From: Erin Moore
Sent: Monday, March 31, 2014 10:15 AM
To: Kaycee Hathaway
Subject: FW: Kittitas County Notice to Agencies: BL-14-00008 Kuchin

BL-14-00008 Kuchin

# KUCHIN PROPERTY

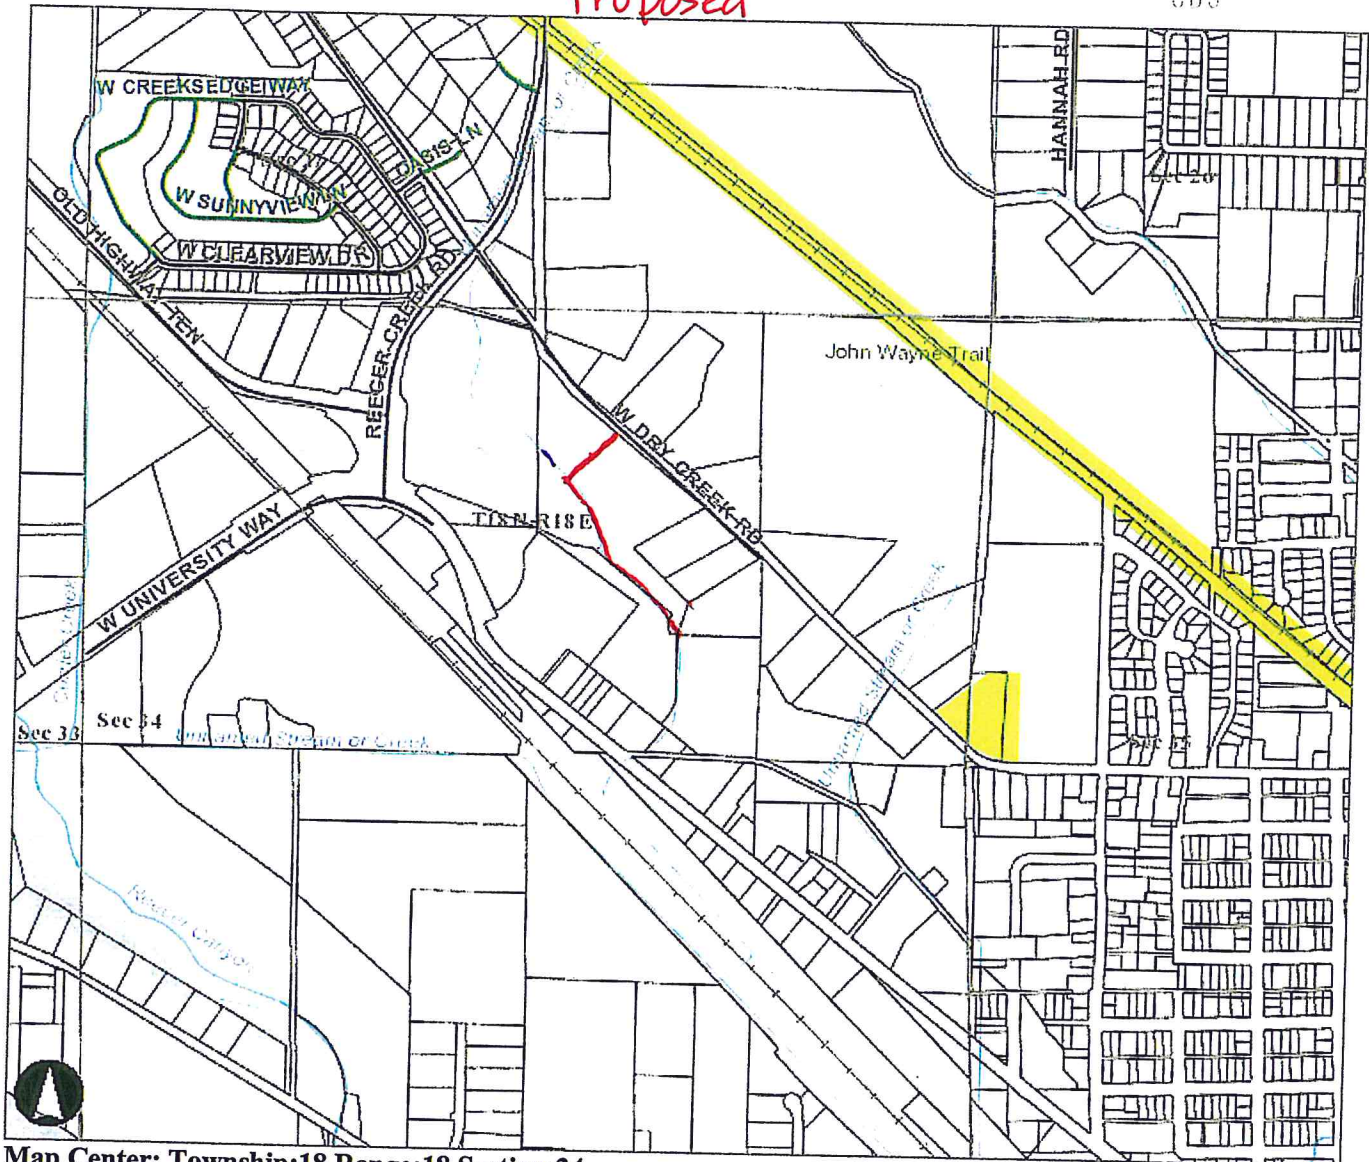
We need to have existing well and septic systems/drainfields identified. Is there an existing cemetery located in this BLA?
